Planning Application Reference No.: 3/2026/0562

Address of Development: Blackburn Rovers Training Ground
Brockhall Village

**Objection to planning permission Ref. 3/2026/0562
Proposed Floodlighting and New Covered Seating
Blackburn Rovers Training Ground, Brockhall Village, Old Langho, BB6 8BA**

Drawing file: planx_downloads / 26_0562_Lighting_Information.pdf

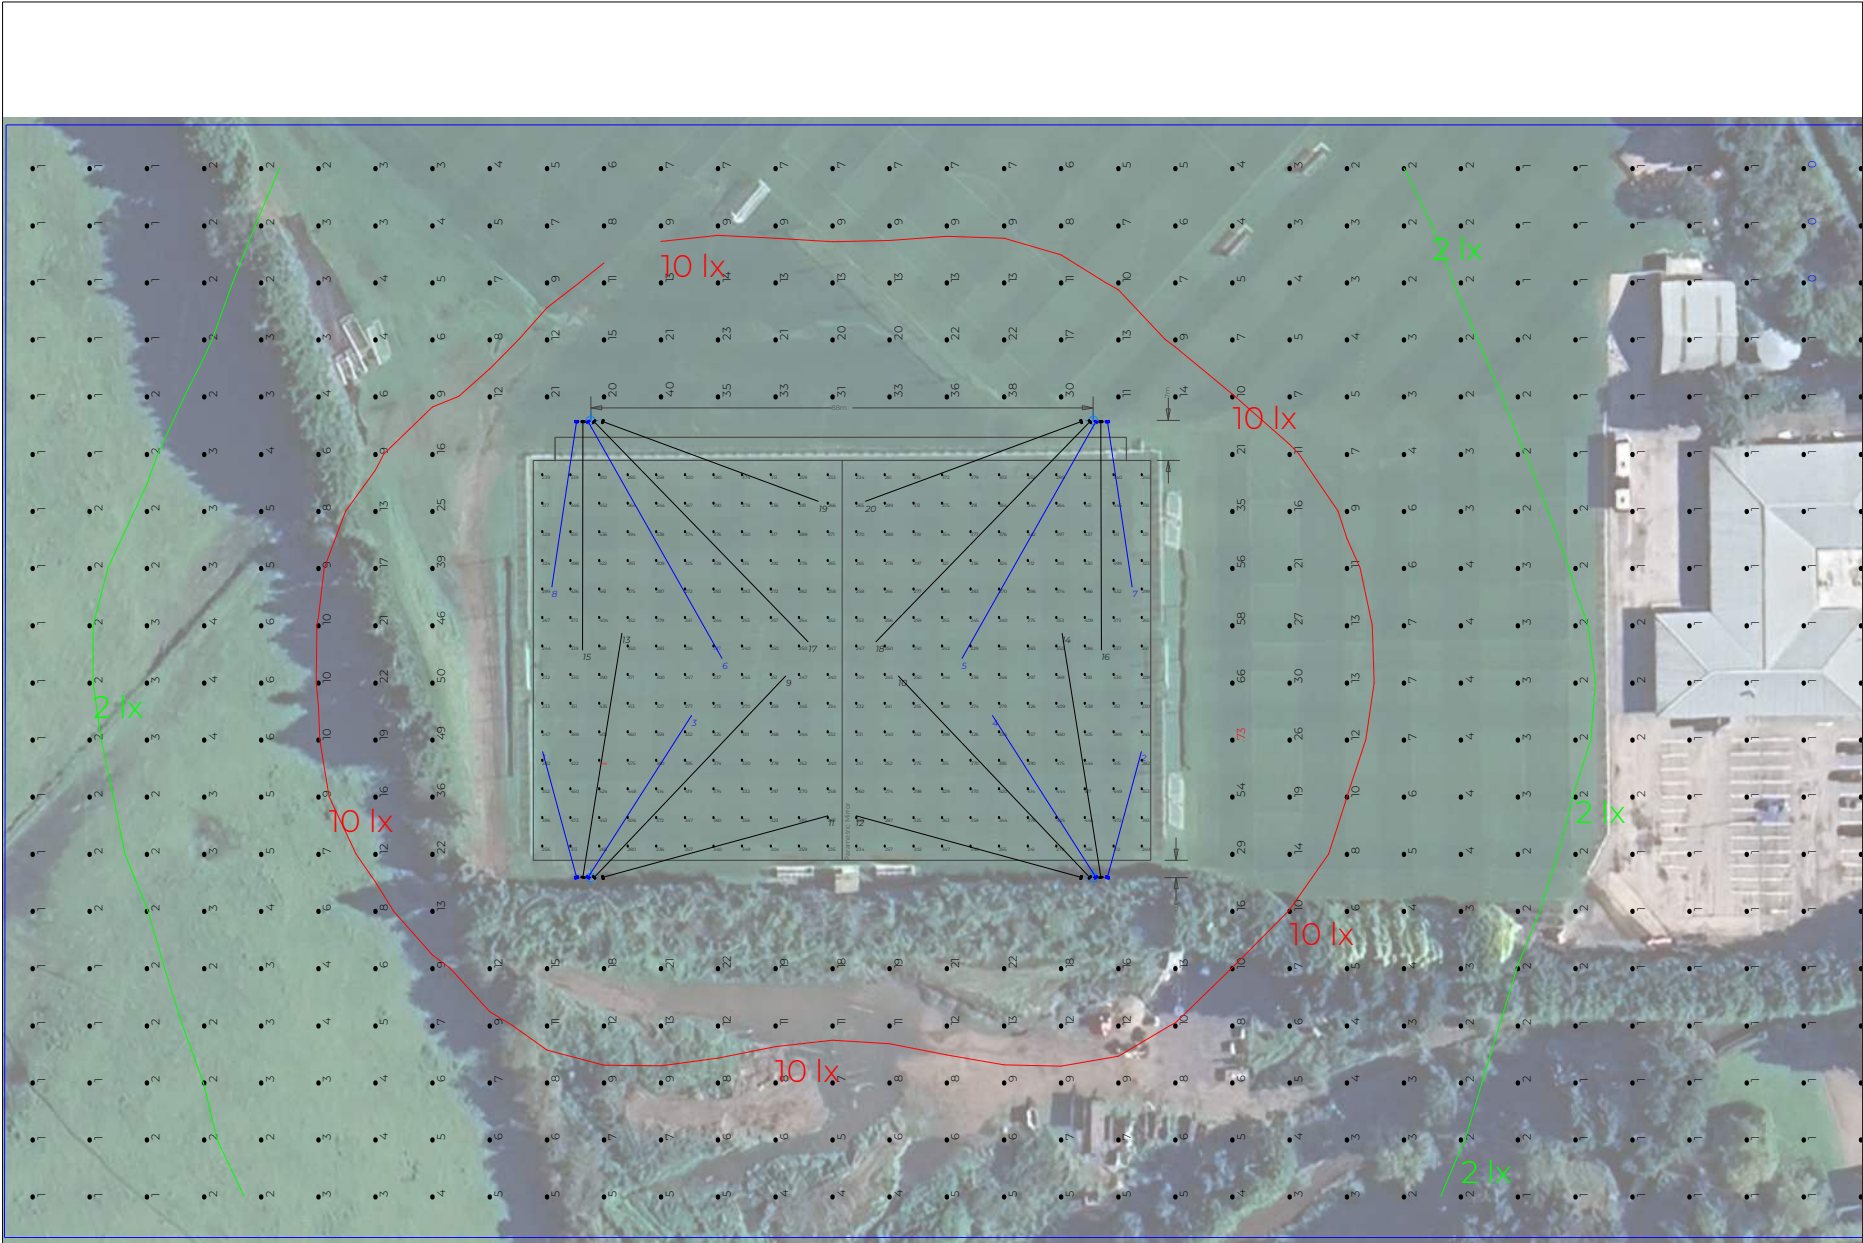
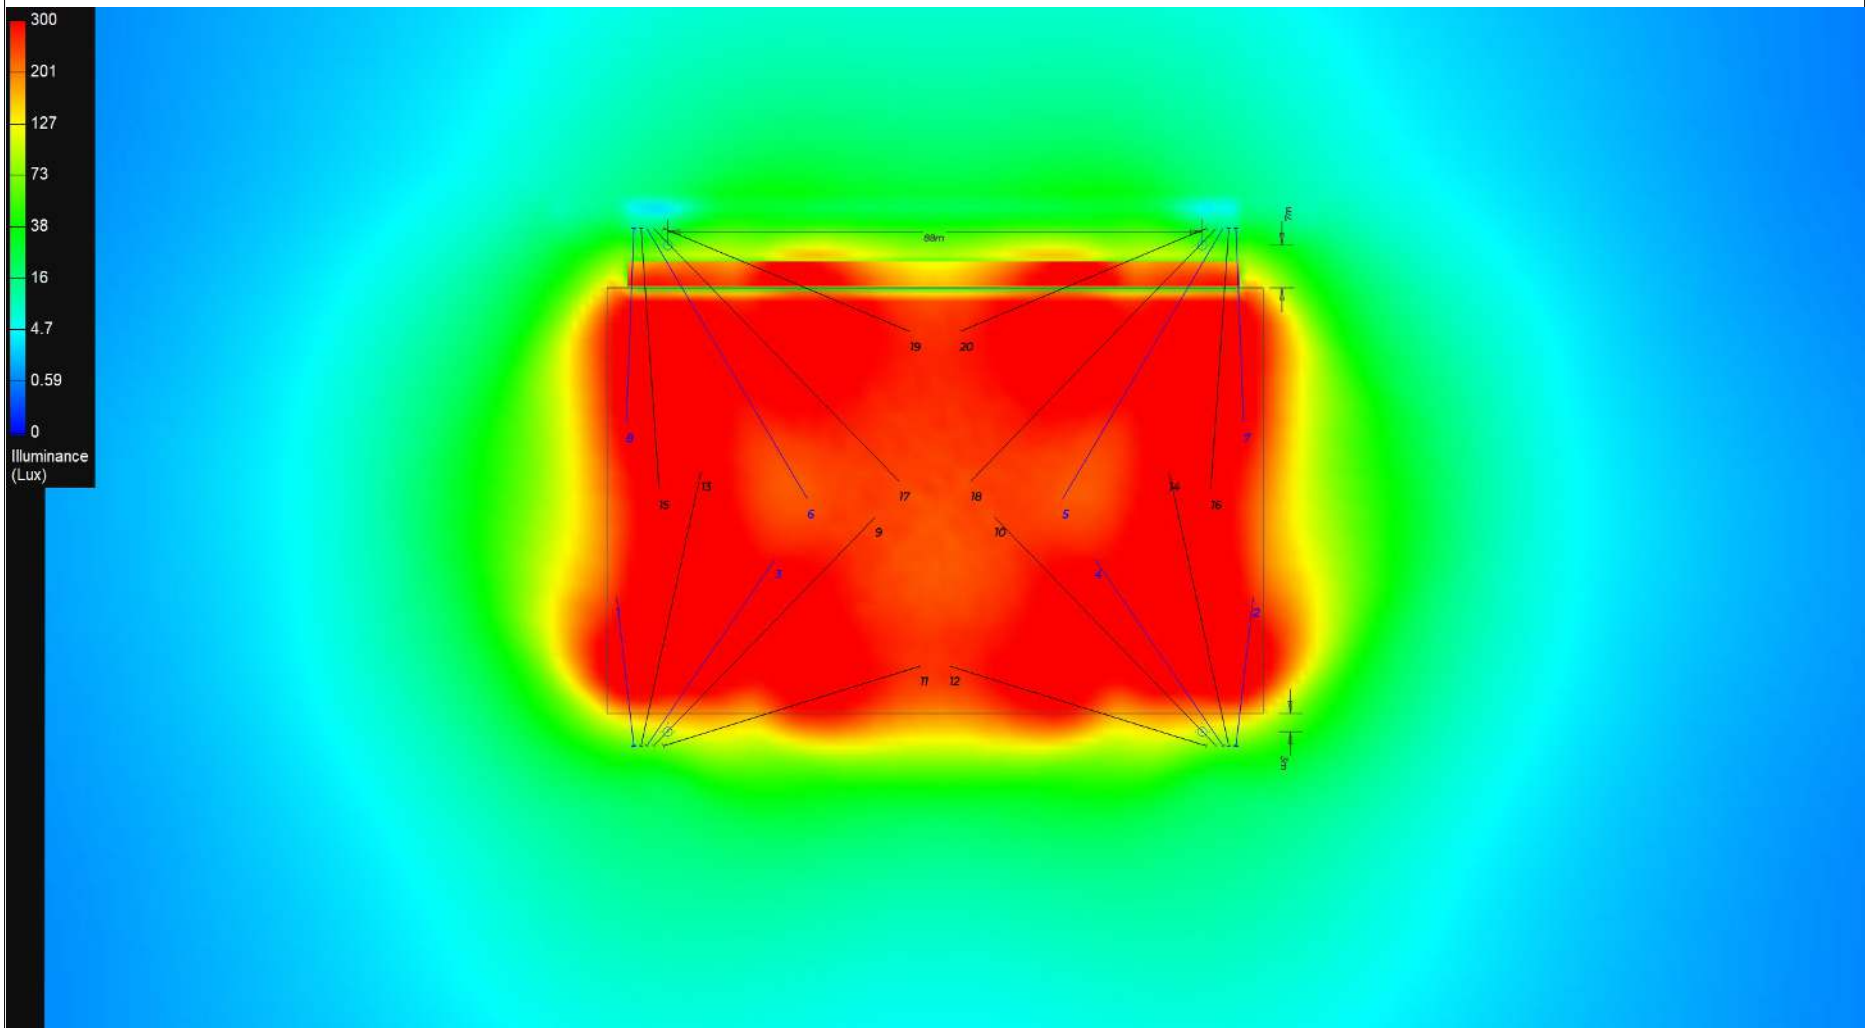
Whilst the application is supported by a document pertaining to be a Lighting Assessment, this does not contain a lighting assessment nor is there a proper light spillage plan. As a result, the Council is unable to carry out a robust assessment of the impact of the proposed lighting and spillage from it.

Done correctly, a light spillage plan would comprise full and complete details of lighting levels across the entire site and beyond the site boundary, including light contour plans. The lighting levels would then be cross referenced against the Institute of Lighting Professional Guidance Note 01/21 'The Reduction for Obtrusive Light'. It is our professional view that the site falls in Environmental Zone I and thus that very strict standards should apply both pre and post curfew.

Given local topography, in this case an assessment also needs to be provided of sky glow. For Environmental Zone I, the guidance states there should be 0% upward glow. Floodlighting at the senior site demonstrates the lighting is unlikely to comply with this requirement.

The report is also vague in respect of its operation. It states that the lighting system would be controlled by a "time clock or suitable control system", but it does not specify the proposed curfew, the number of days per week the lights would operate, or the precise times at which they would be switched on and off. These are critical matters for local residents and should not be left unresolved. Without clear restrictions on hours and frequency of use, the proposal creates an unacceptable risk of light pollution and harm to residential amenity.

Drawing file: planx_downloads / 26_0562_Prop_Floodlighting_Layout.pdf

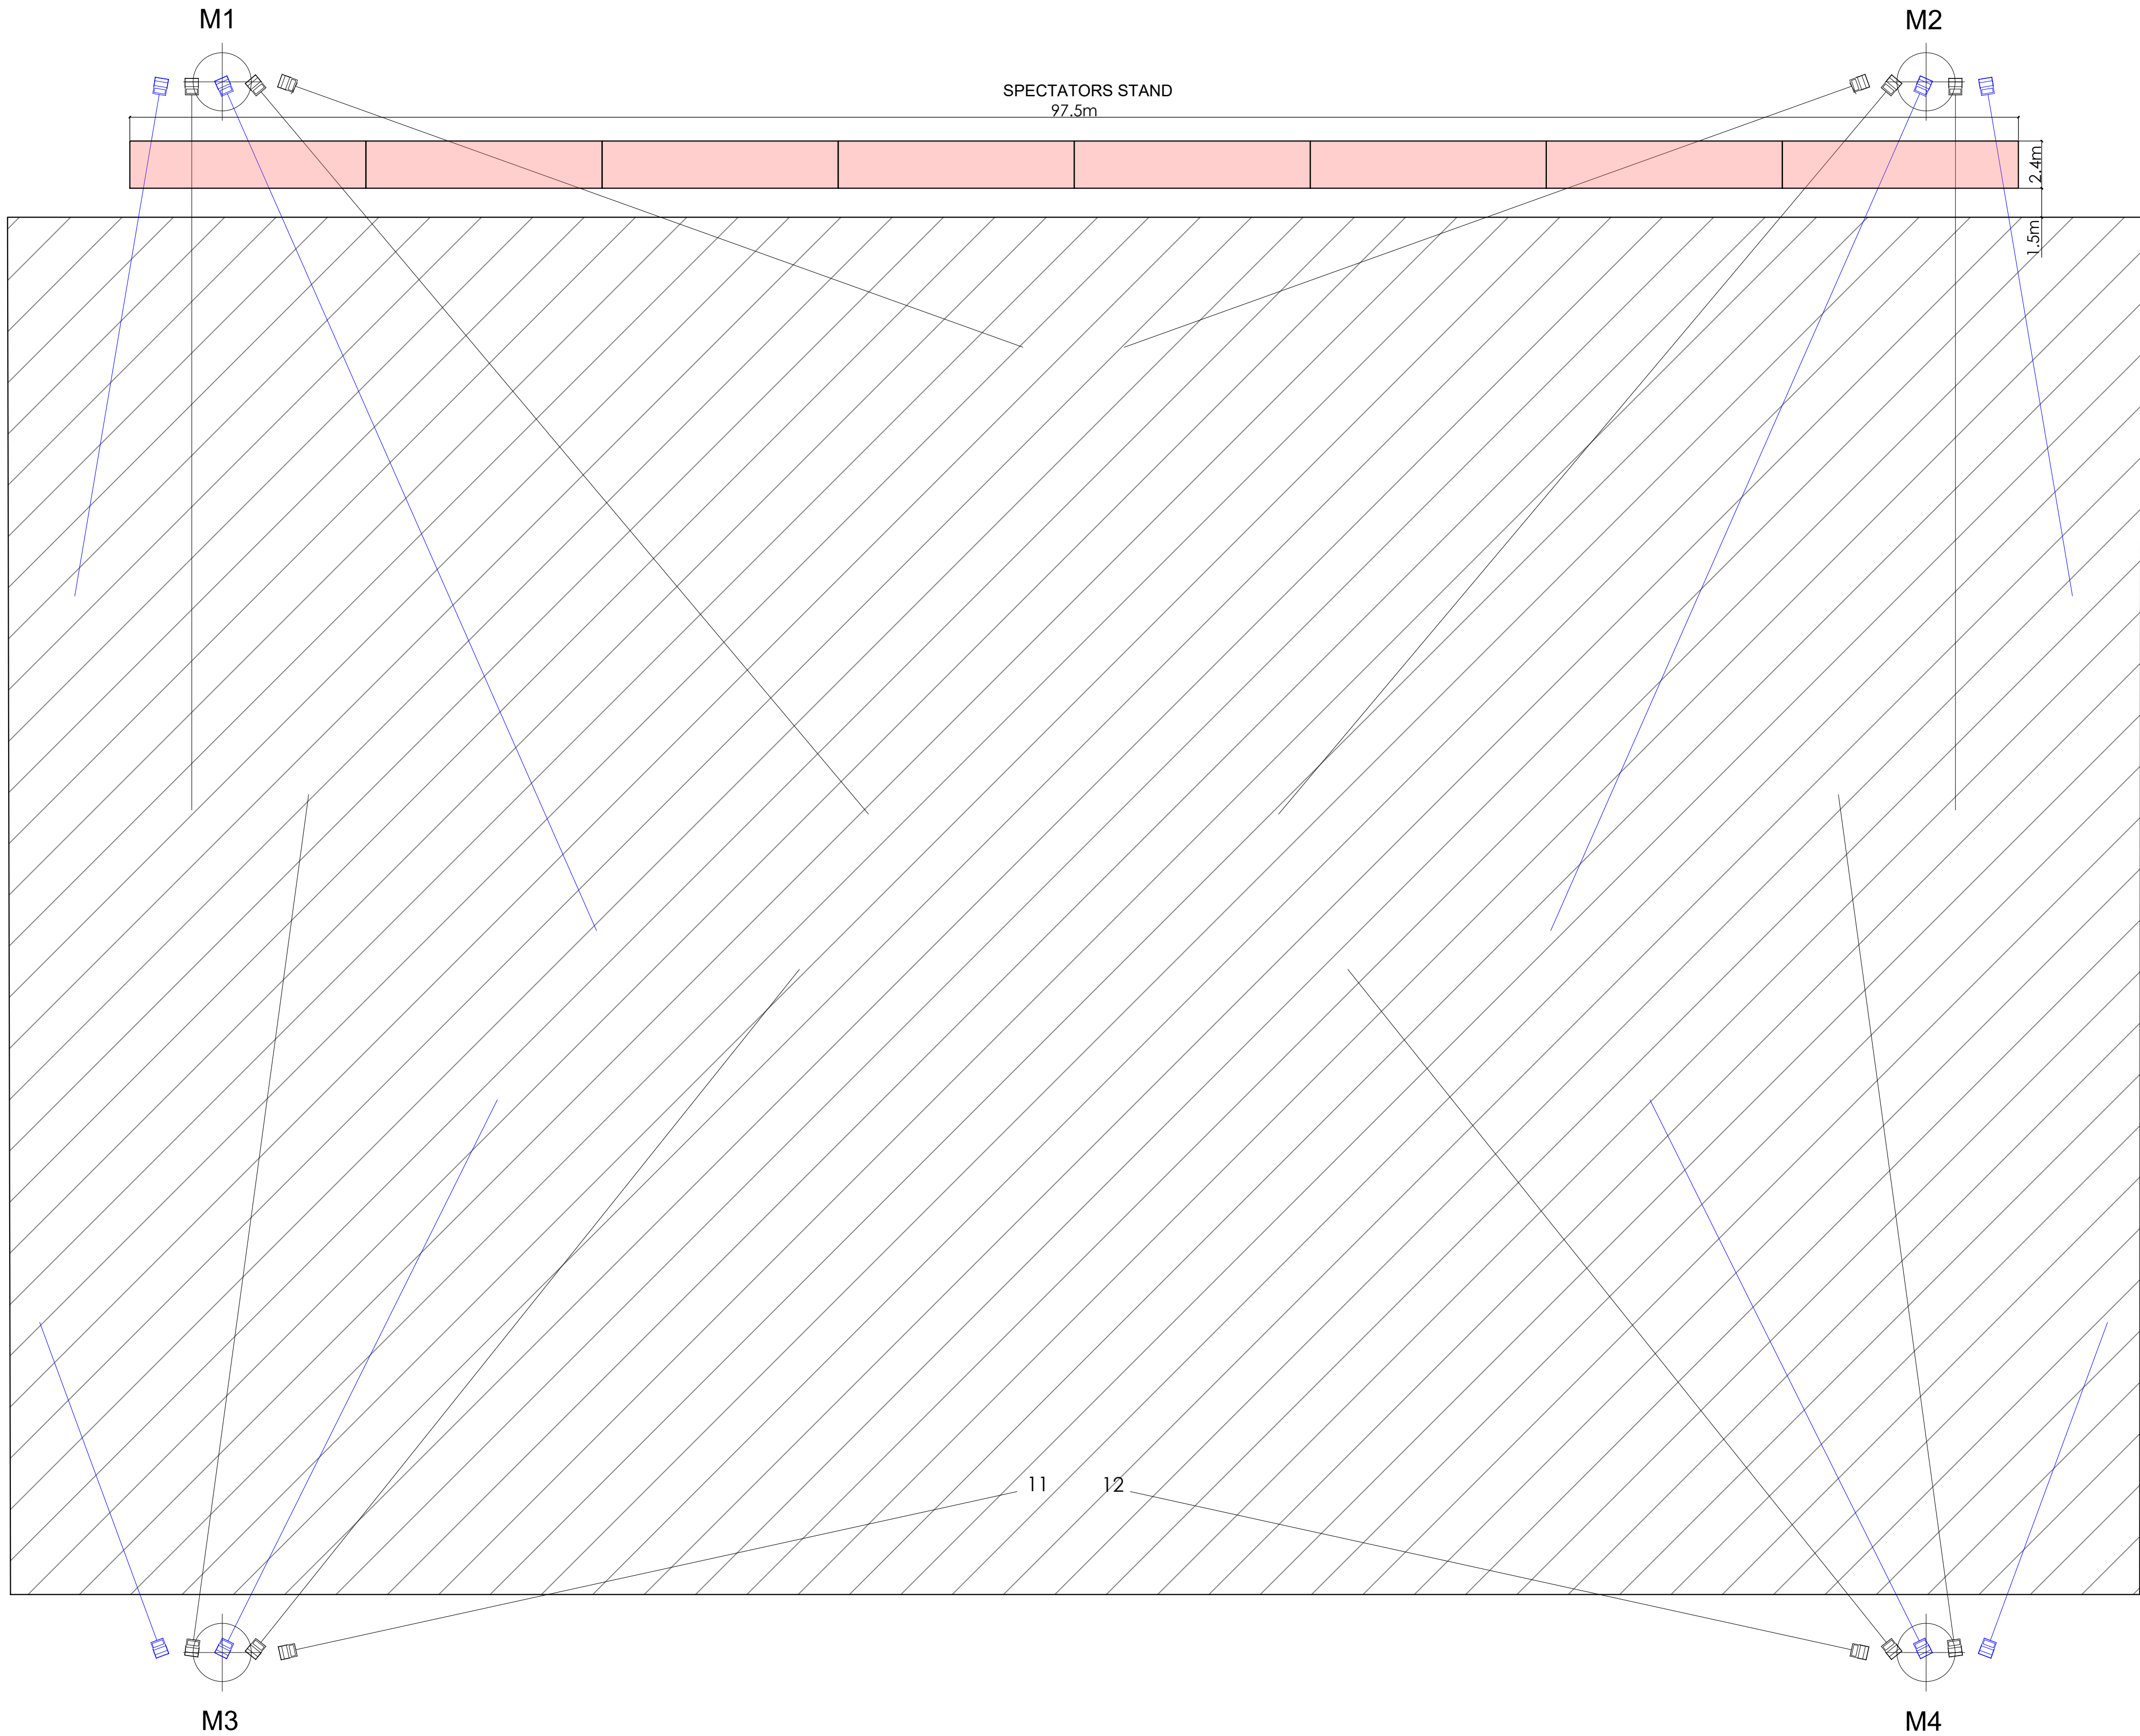
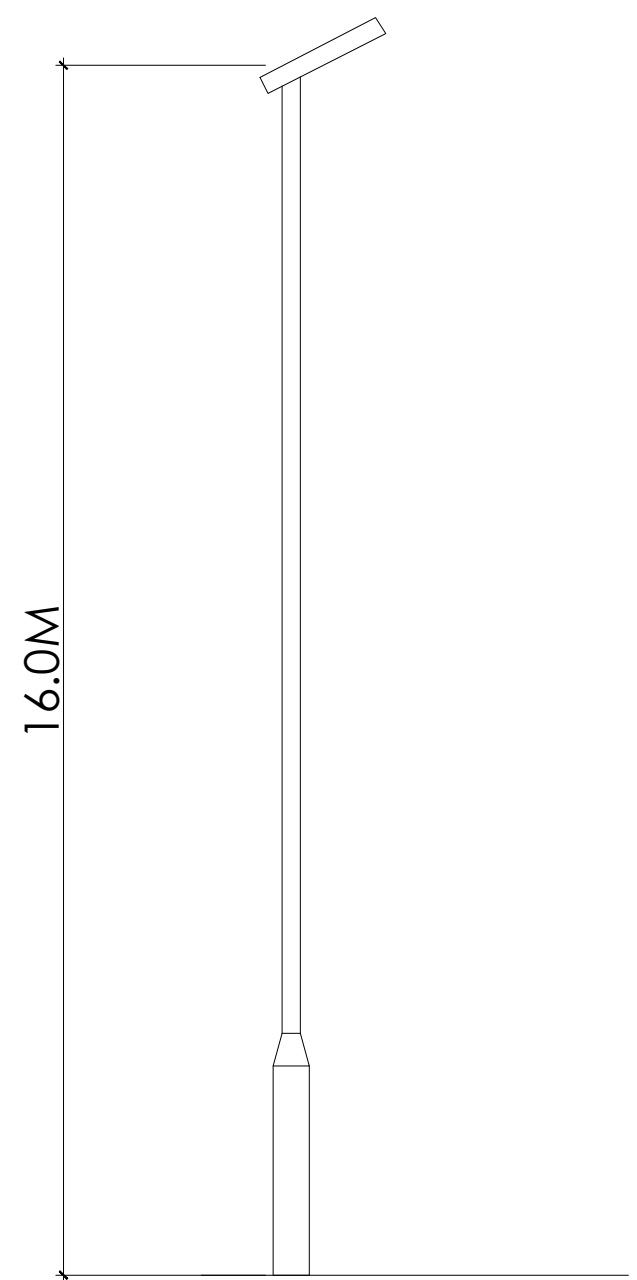
With regard to the lighting, it is proposed to erect four no.16 metre high columns onto which will be installed 5 individual lights. The floodlights will provide full illumination of the entire pitch.

Notwithstanding the comments above with regard to the principle of floodlighting in this location, the lighting is also considered unacceptable on account of the light pollution and light spillage it will almost certainly cause. This is clear when one looks at the impact of the existing floodlight at the senior site which not only spills widely beyond the site boundaries, but also extensive upwards creating significant sky glow, which is visible a significant distance from the site.

Notwithstanding this fact, the submitted details are considered wholly inadequate and insufficient to enable a robust assessment of the impact of the proposed lighting. Furthermore, if approved with this level of information it would be impossible for the Council to control and thus prevent significant light pollution.
